Preferred Project Report

Block 3B, 3C and 10 Kensington Street

Student Accommodation and Ground Floor Commercial Use

Submitted to Department of Planning and Infrastructure

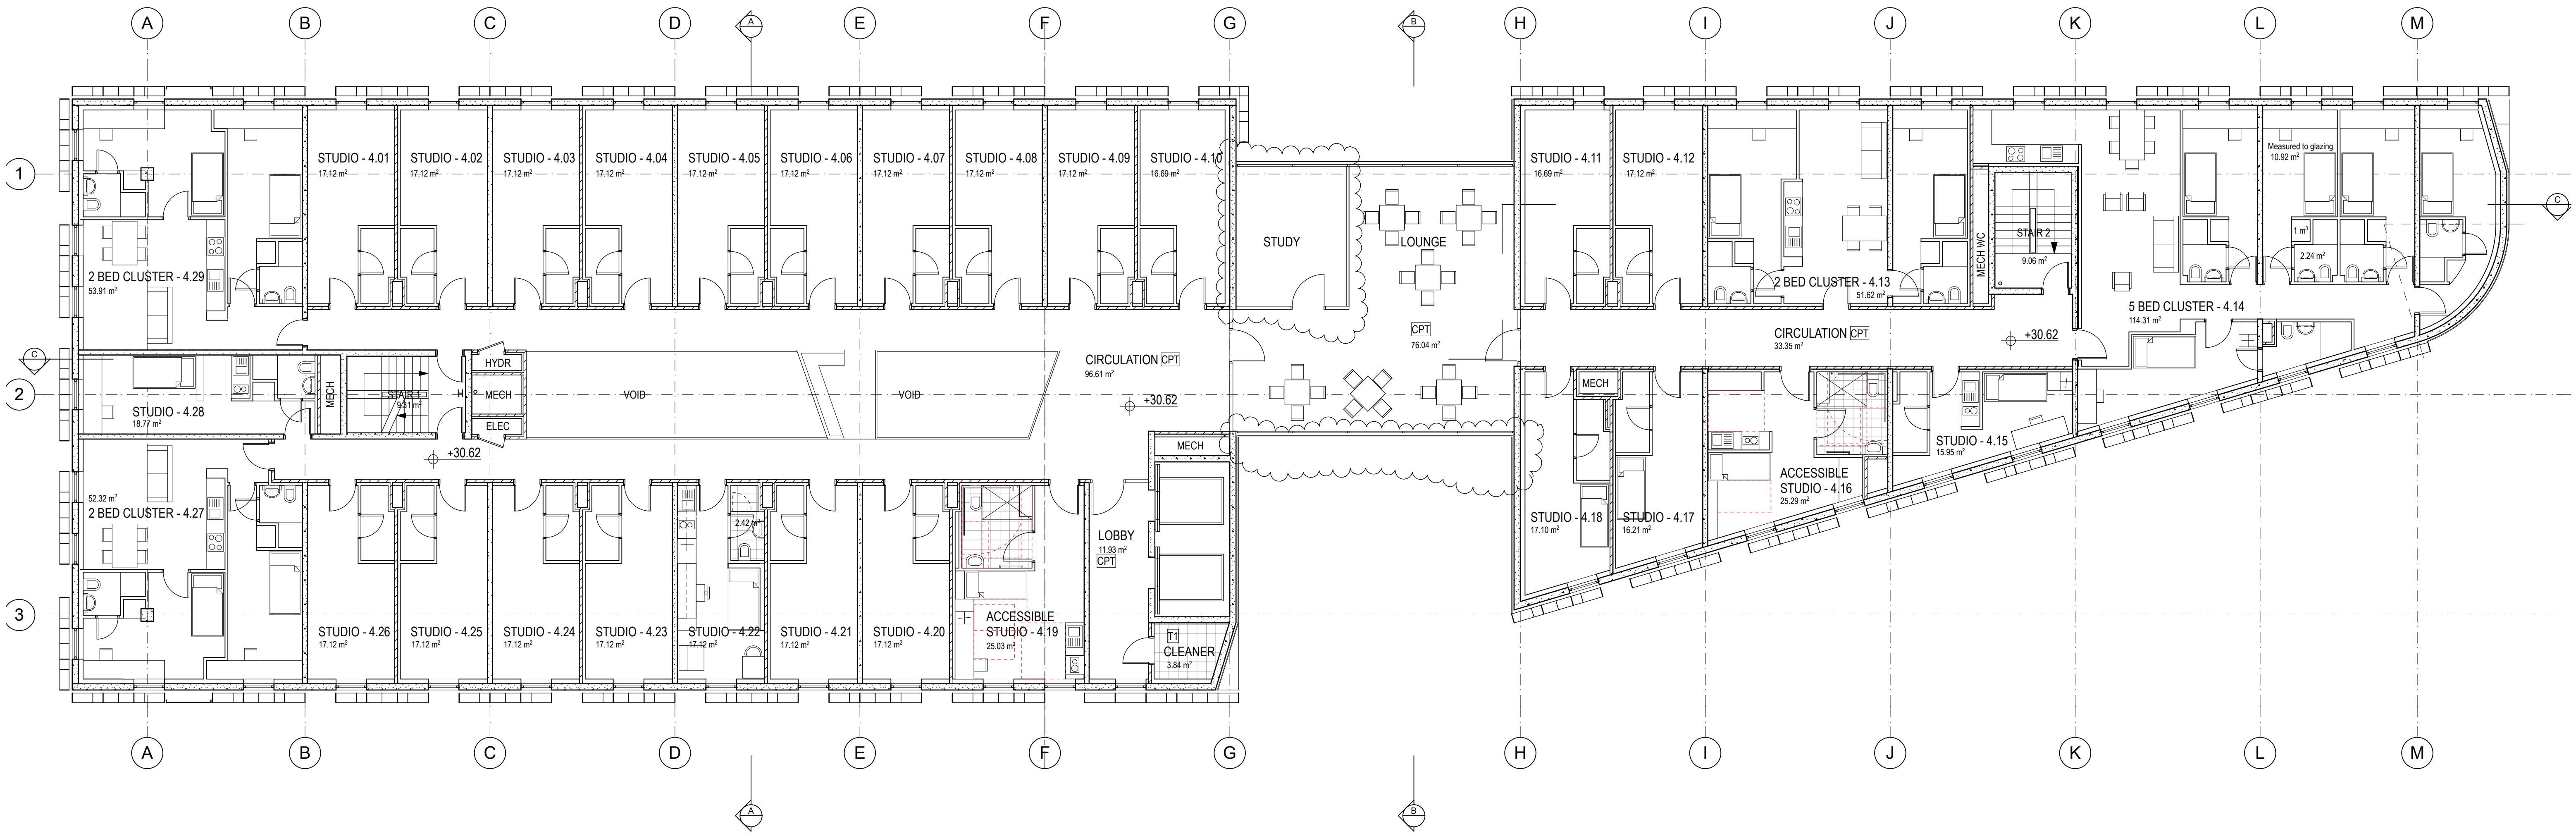
The DPI has suggested consideration be given to the removal of the link at Level 1 between building 3B and 3C. The revised project application deletes the link between these buildings in accordance with this recommendation. The existing stair to building 3C with access from Kensington Street can be used to access the residential accommodation to level 1 of the Building 3C.

The floor plate of Block 3B and 3C has also been revised to remove an additional staircase to the centre of the buildings between levels 2 and 6, and reduce the width of the link bridge from level 2 and above.

The proposal also involves the internal reconfiguration of the central link between Block 3B and 3C between levels 2 and 6. The removal of these stairs has been considered in the revised BCA report prepared by City Plan Services (**Appendix D**). The areas previously occupied the stairs has been converted to be used as study areas to each level. The links between levels 2 and 6 has also been further set back from the western boundary.

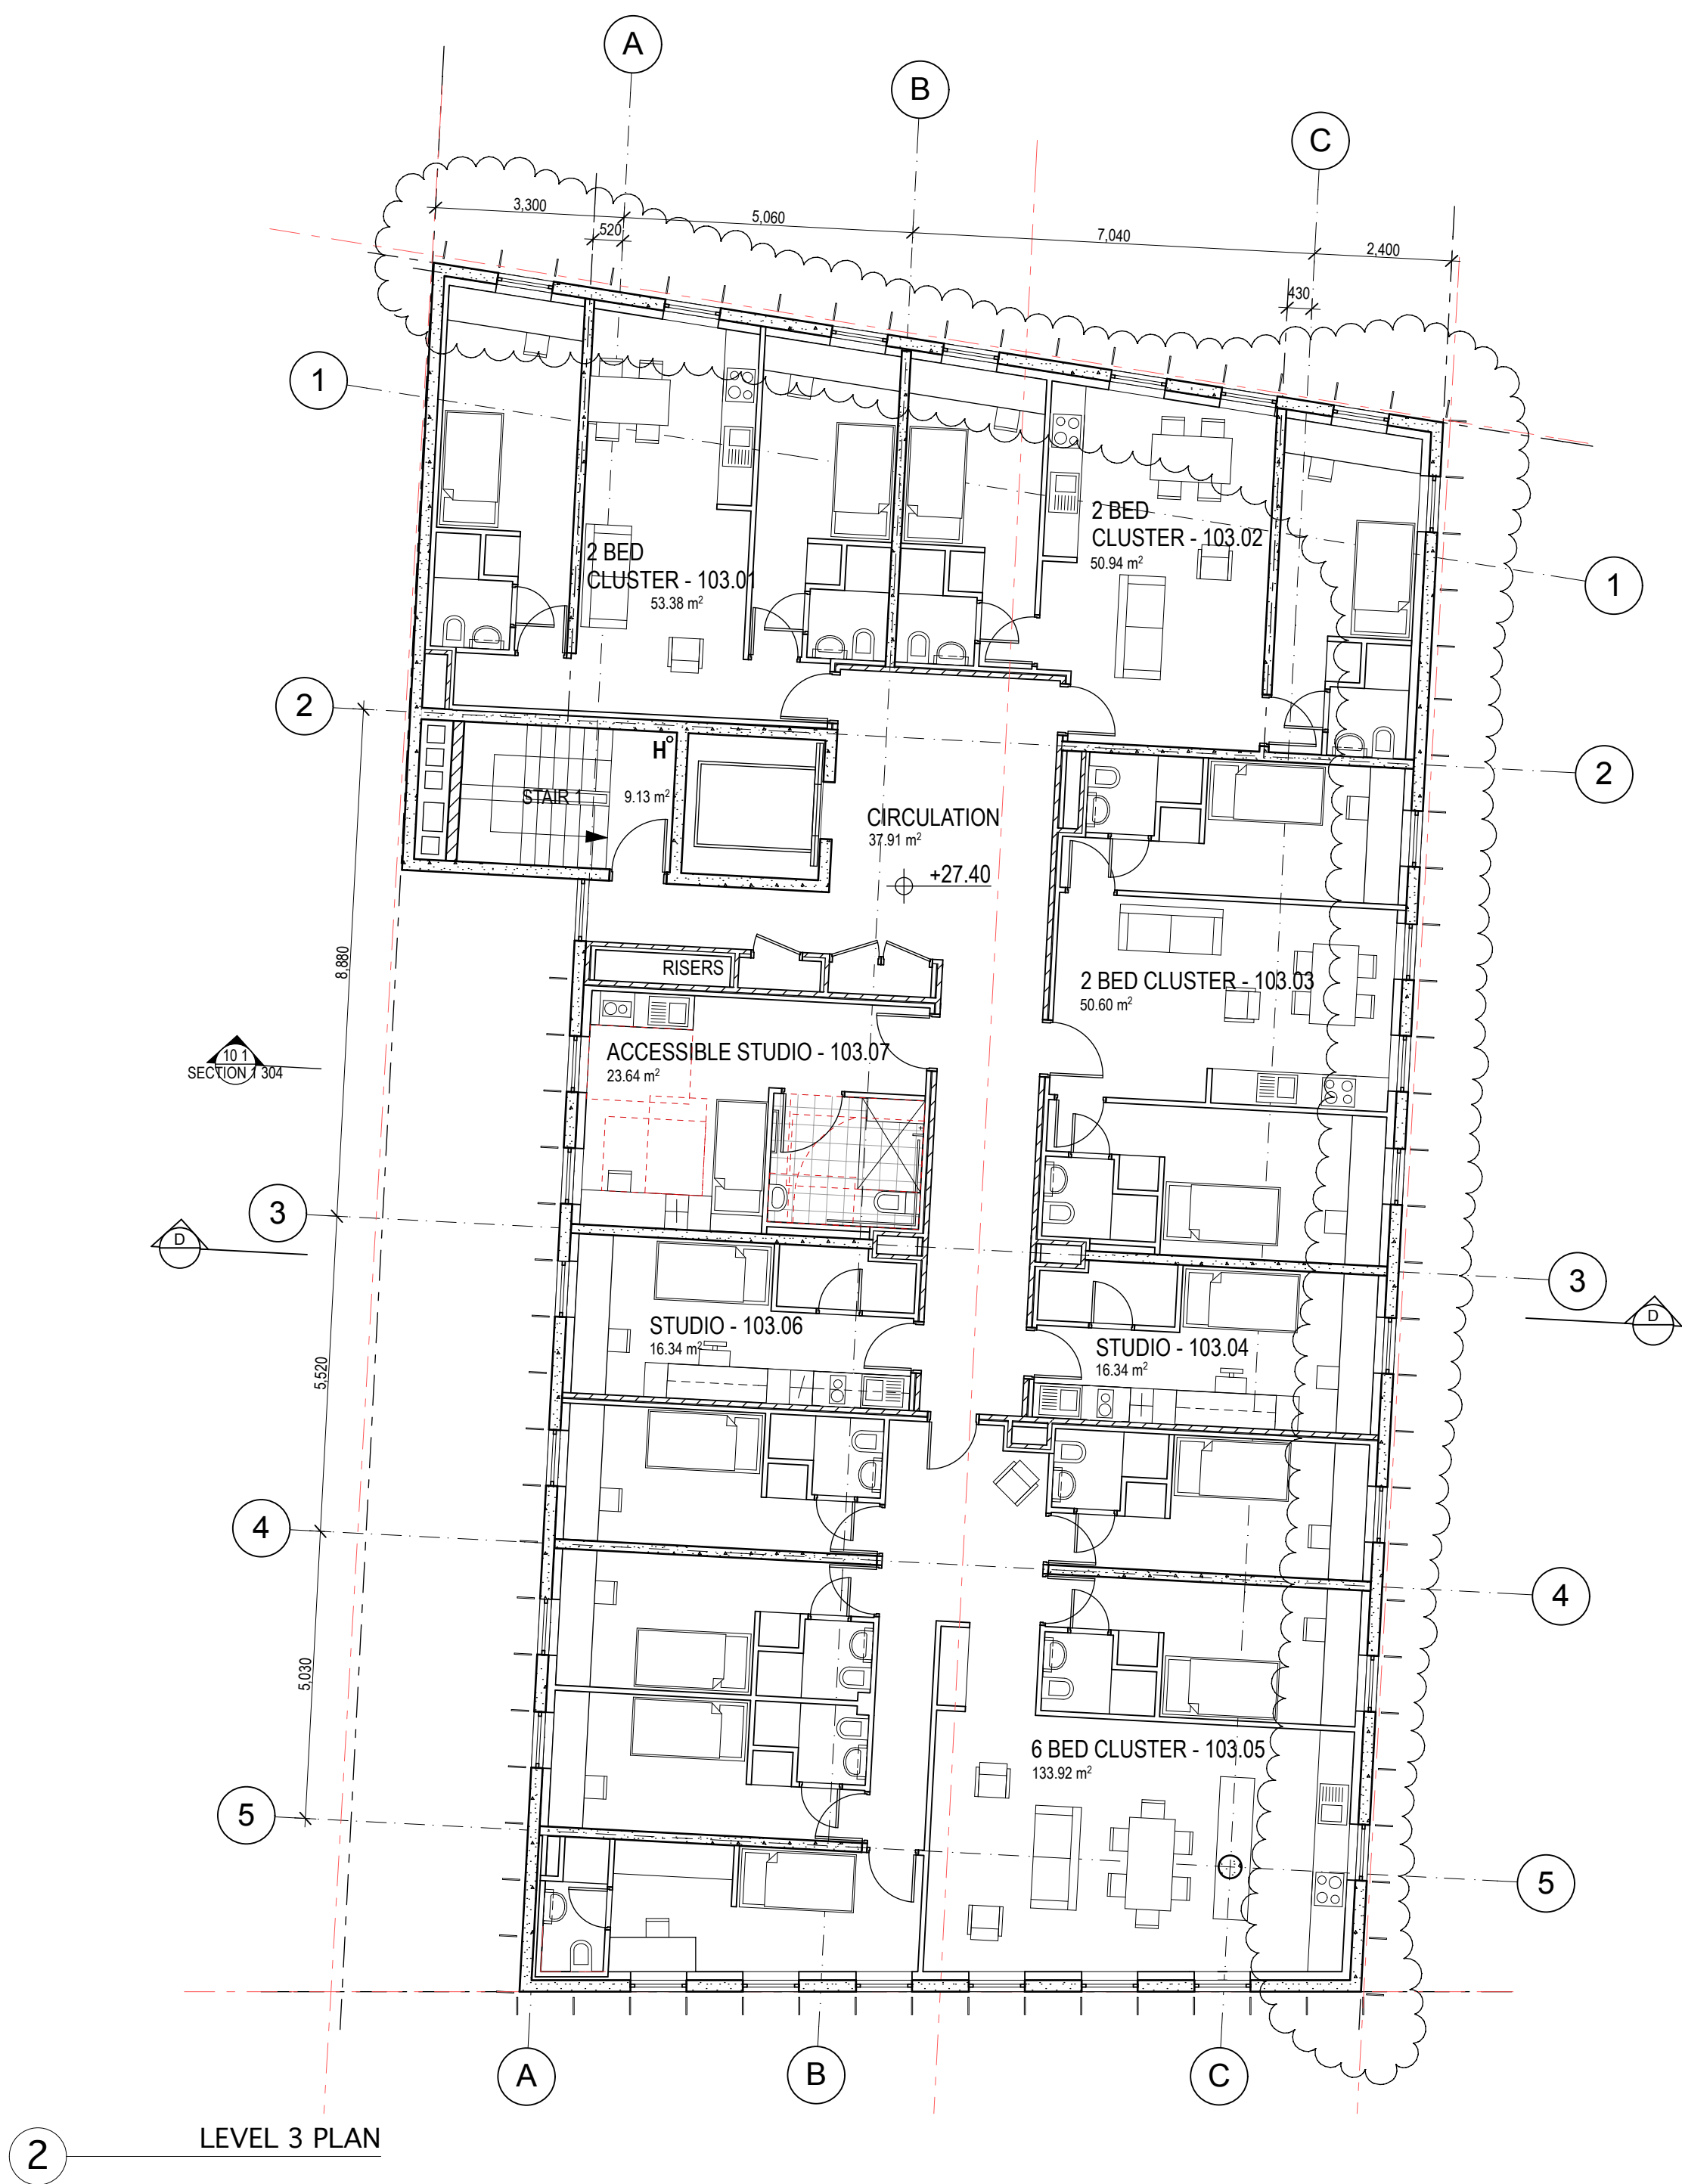
The submission from the DPI refers to the access to, and extent of the trafficable drying area on level 2 of Block 10. The architectural plans have been revised (Plan A-212) to identify the access. The revised plans show three openings from the common room and laundry with two sliding doors to the western elevation of the common room and one from the laundry. The drying area has a total area of 76.5m².
